BR/138/21/DOC

23 Mead Lane Bognor Regis PO22 8AP

Approval of details reserved by condition imposed under ref BR/175/20/PL relating to Condition Nos 3 - covered & secure cycle parking, 4 - brick bonding, 5 - new joinery details and 6 - rooflights.

PARTIAL PROPOSED NORTHERN ELEVATION

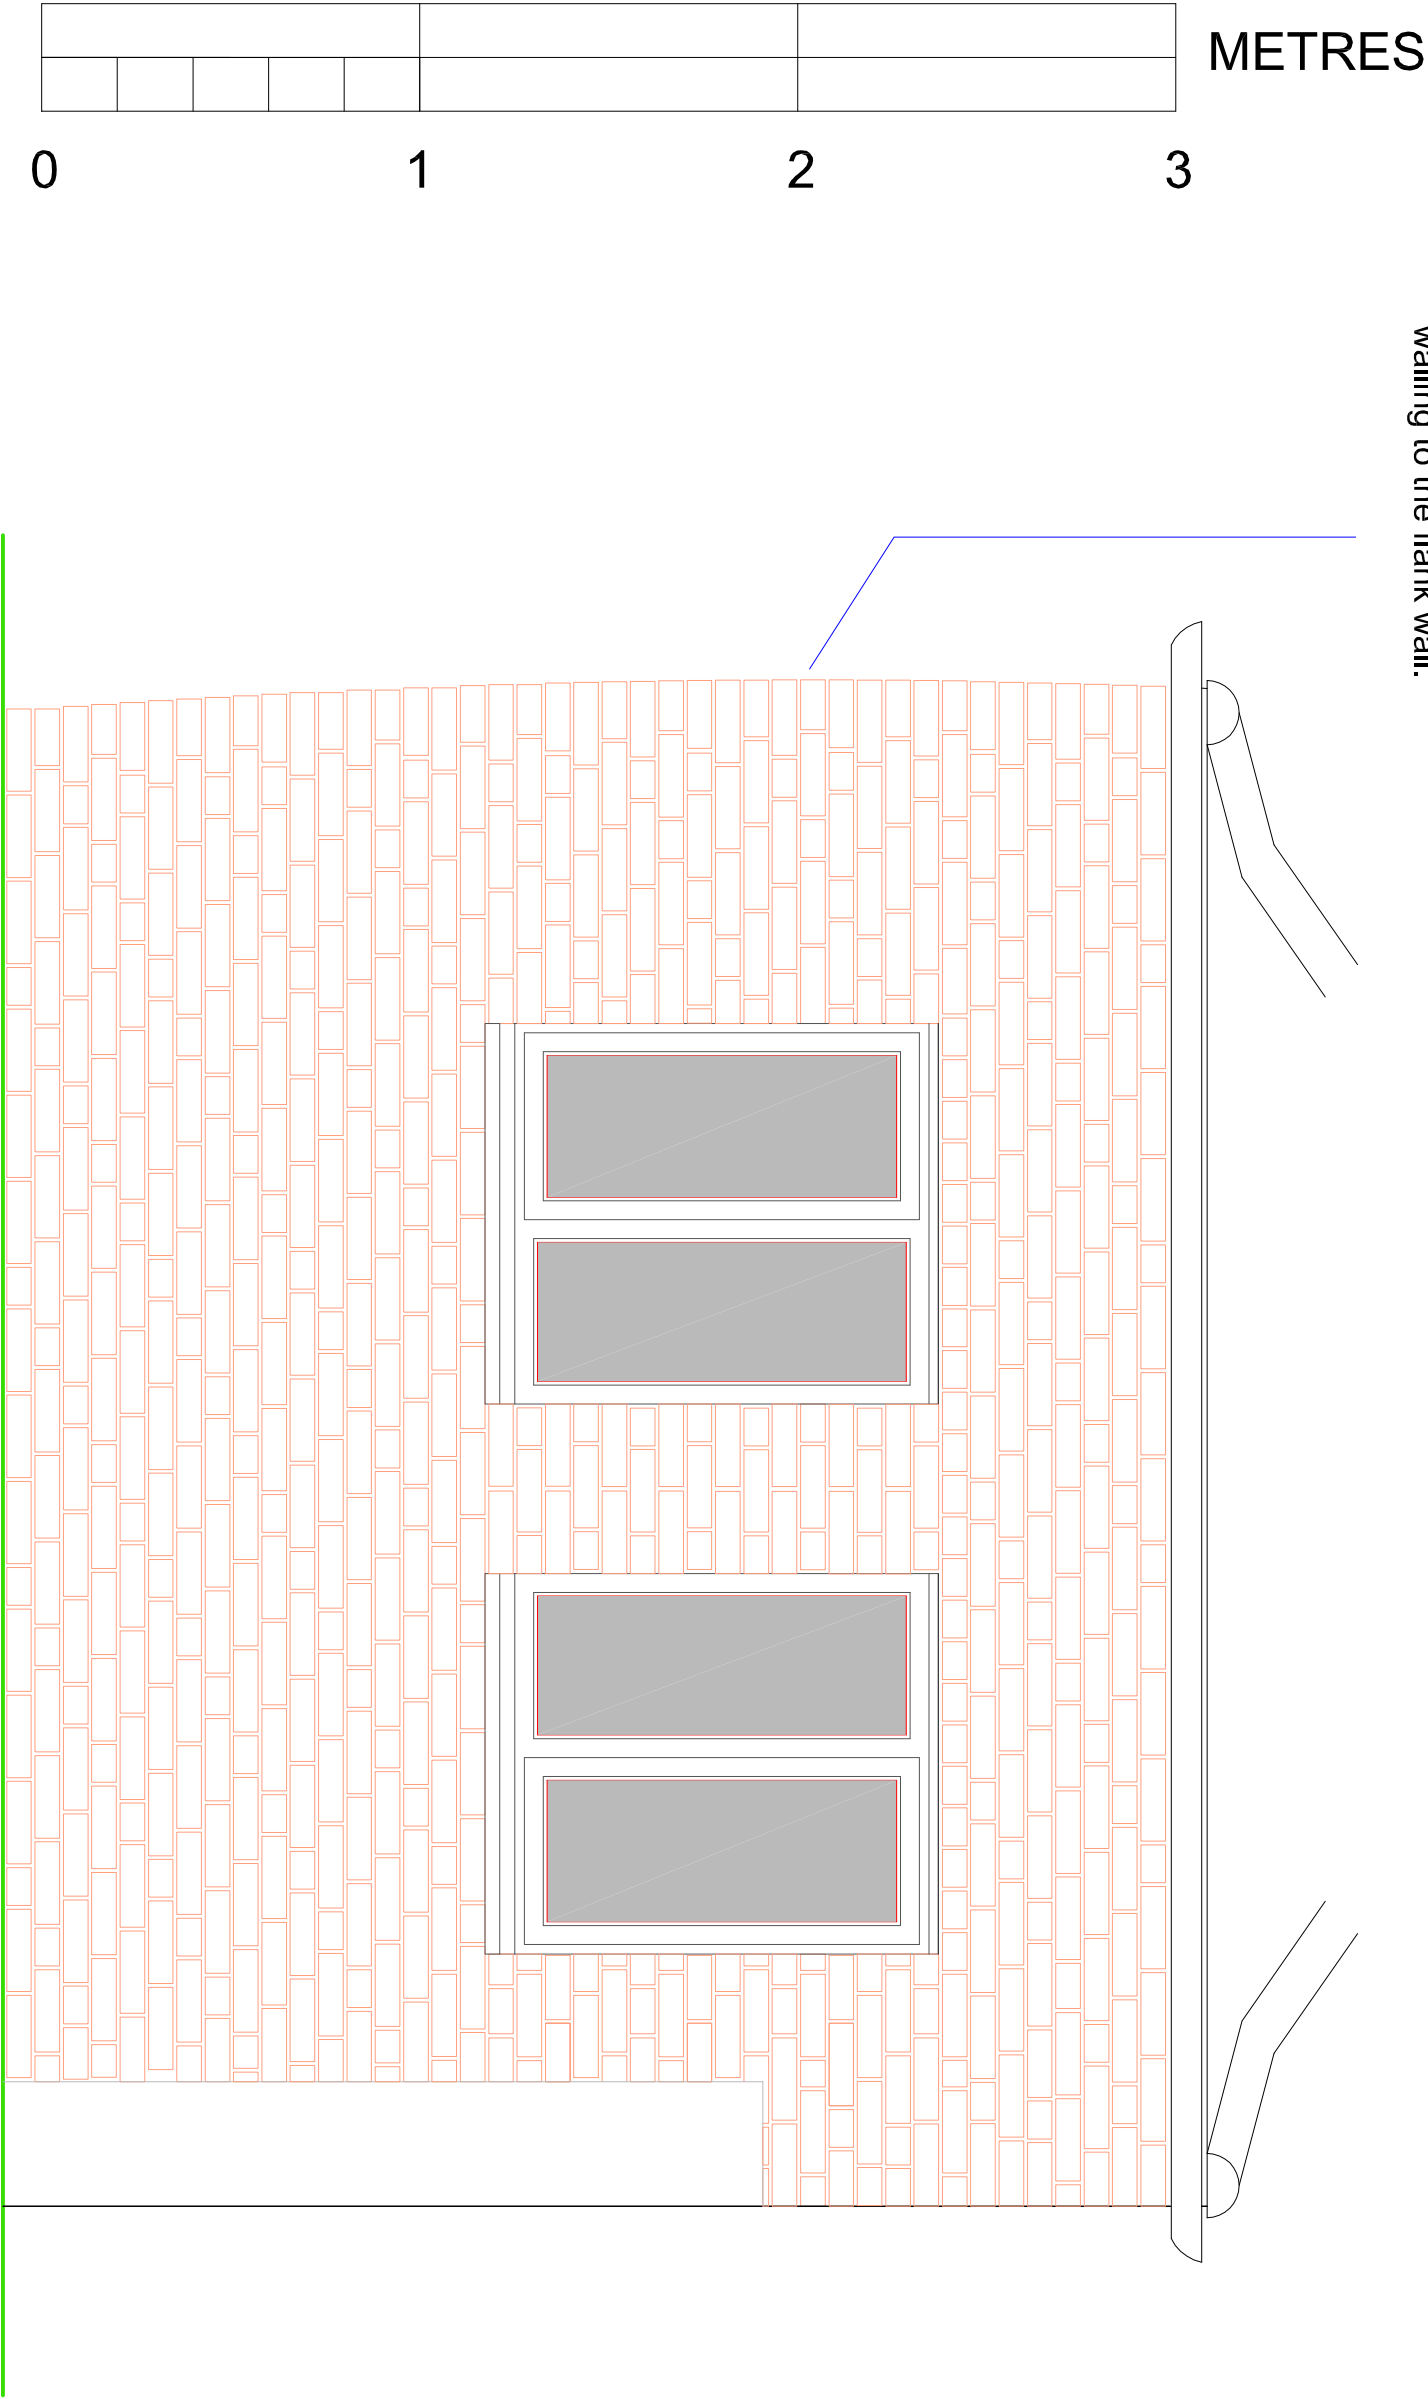
It would help to have it confirmed that any new bricks required to rebuild the section of wall on the northern elevation will match the existing.

Thank you. I note that para 1.12 of the report provided states that the proposal is to re-build the portion of the wall in its entirety with brickwork to match existing, which is positive and capable of support. Likewise, the replacement door is acceptable

1. Brickwork stated to be to match existing.
2. The entrance door to Unit 3 is changed to match that for Unit 2 as requested.

SOUTHERN ELEVATION

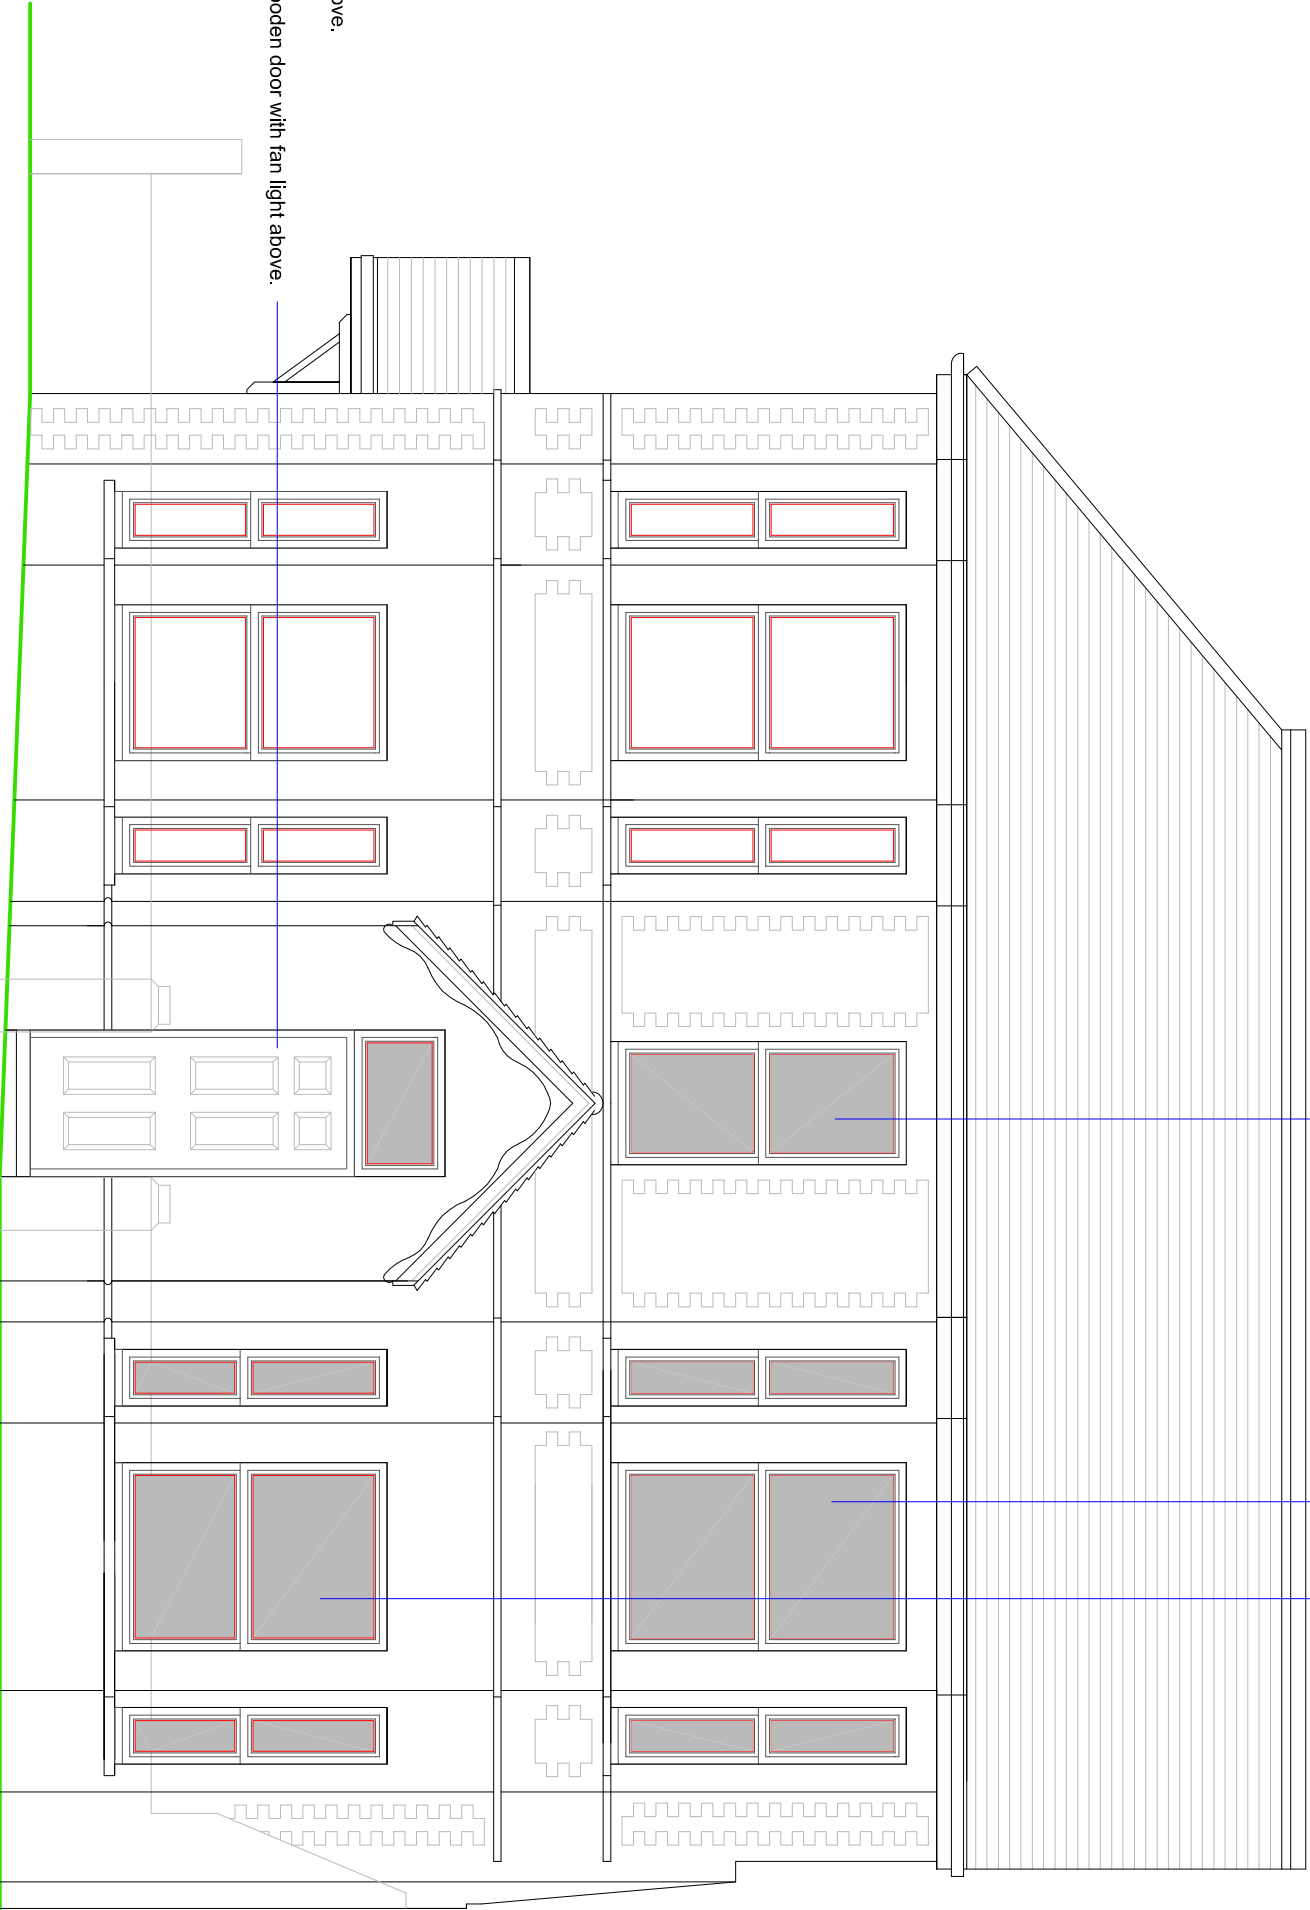
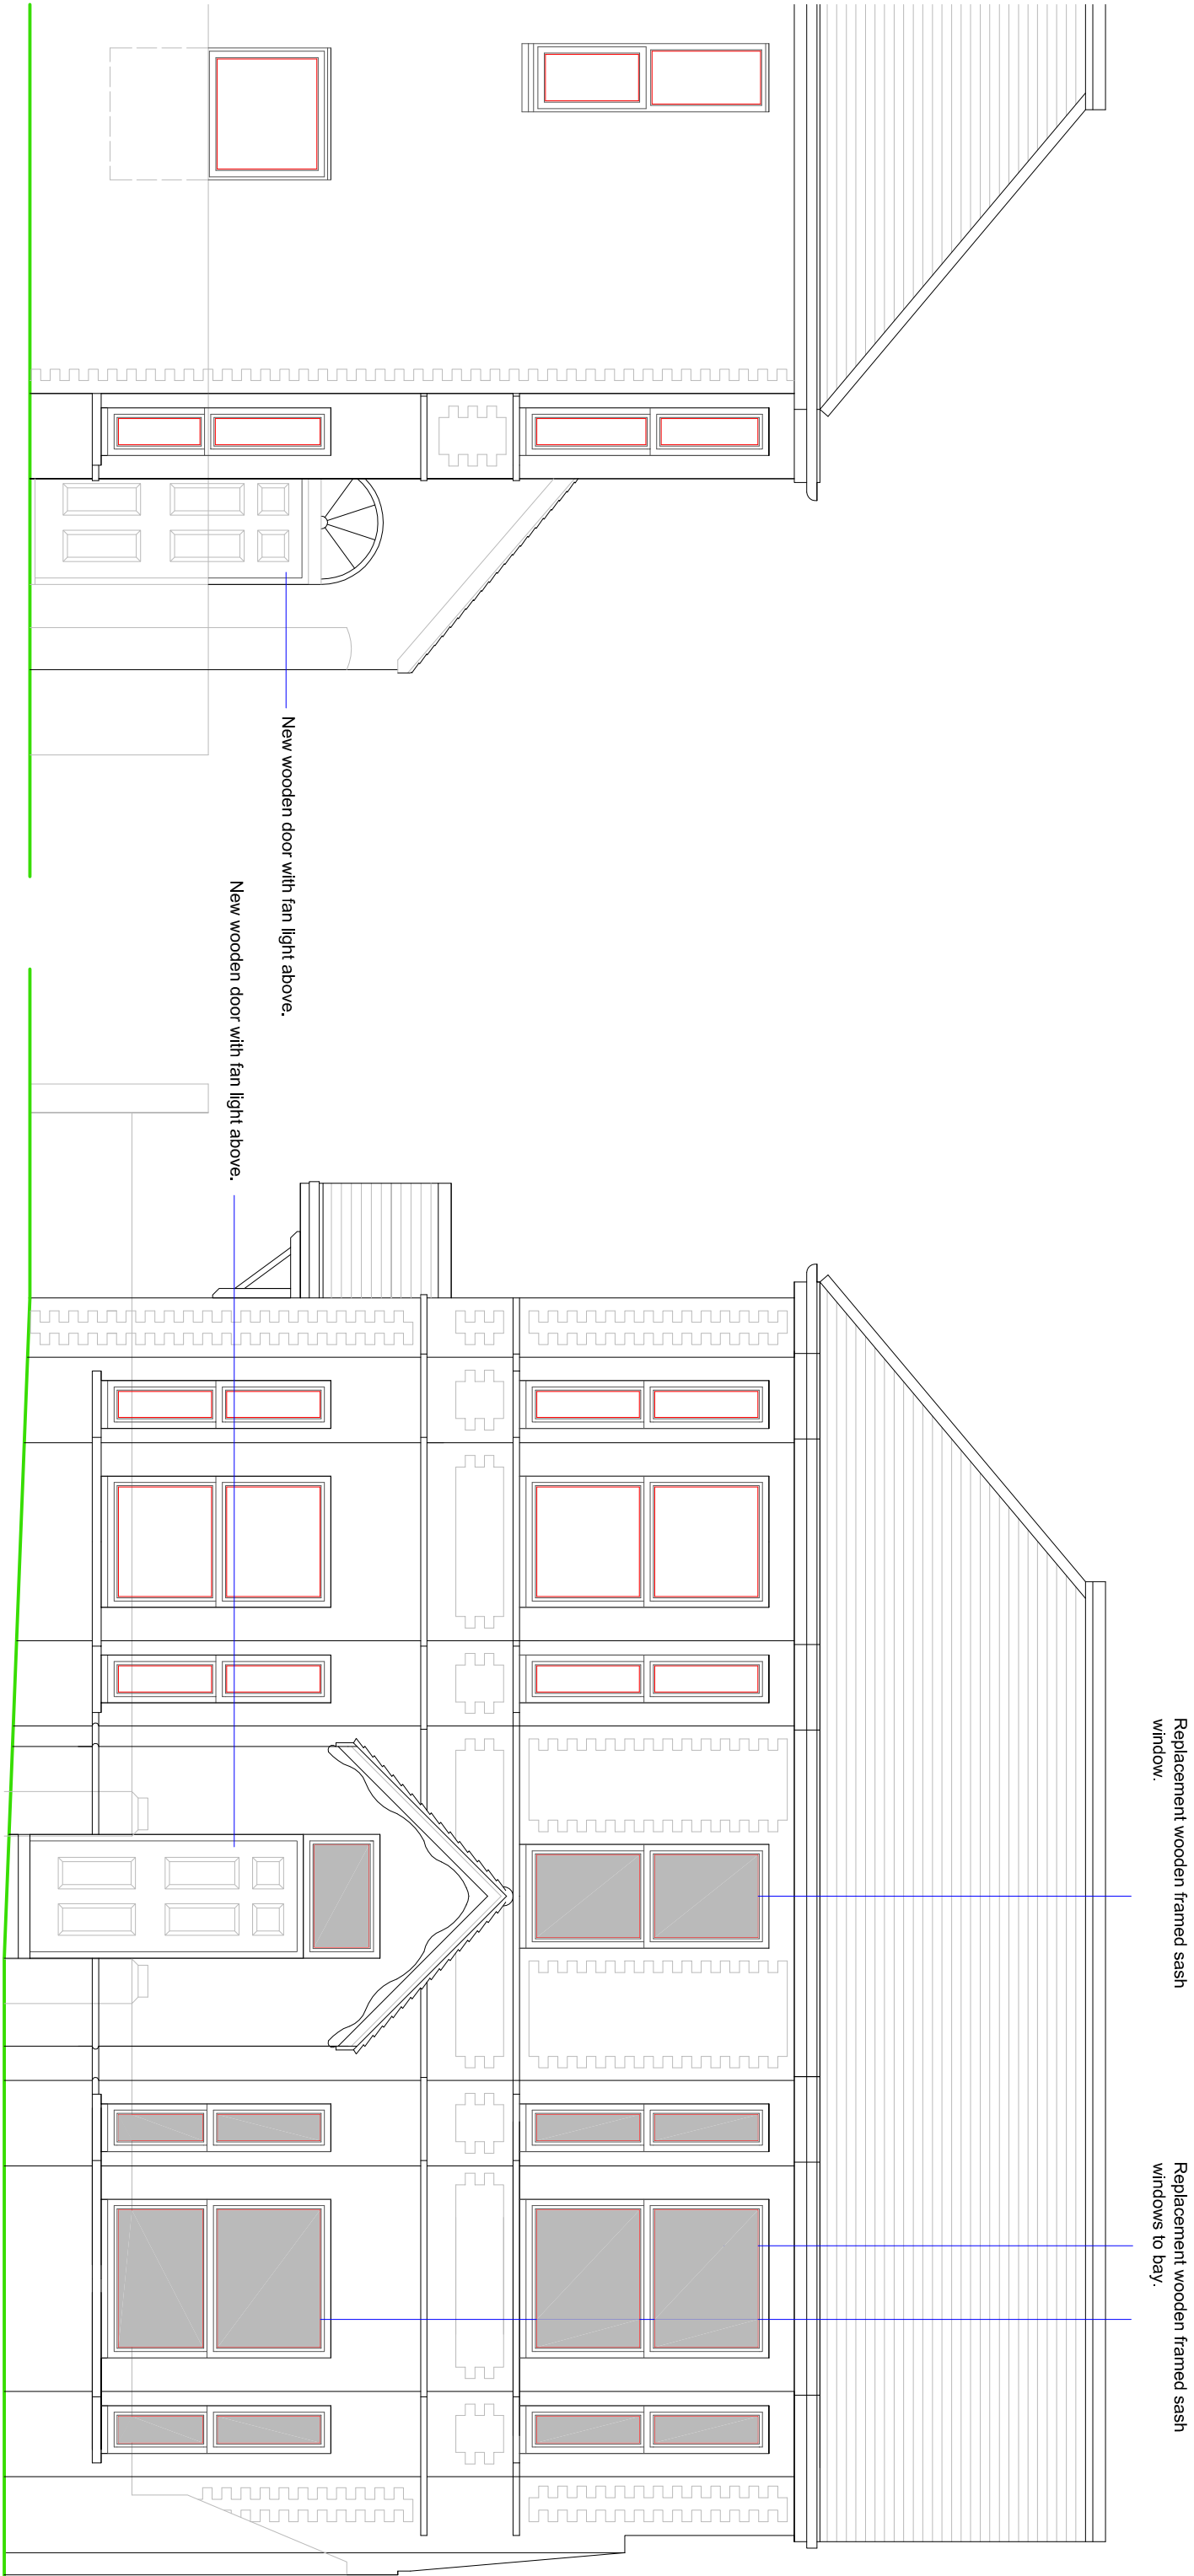
The proposed door which is shown on the southern elevation appears to be a standard type door, with an inbuilt 'fan style' window. This would be located under what looks like an existing fan light. I should point out that it does not appear on the section detail for the door and is not considered appropriate for the building. It is suggested that a more traditional design such as that proposed on the eastern elevation is more appropriate.
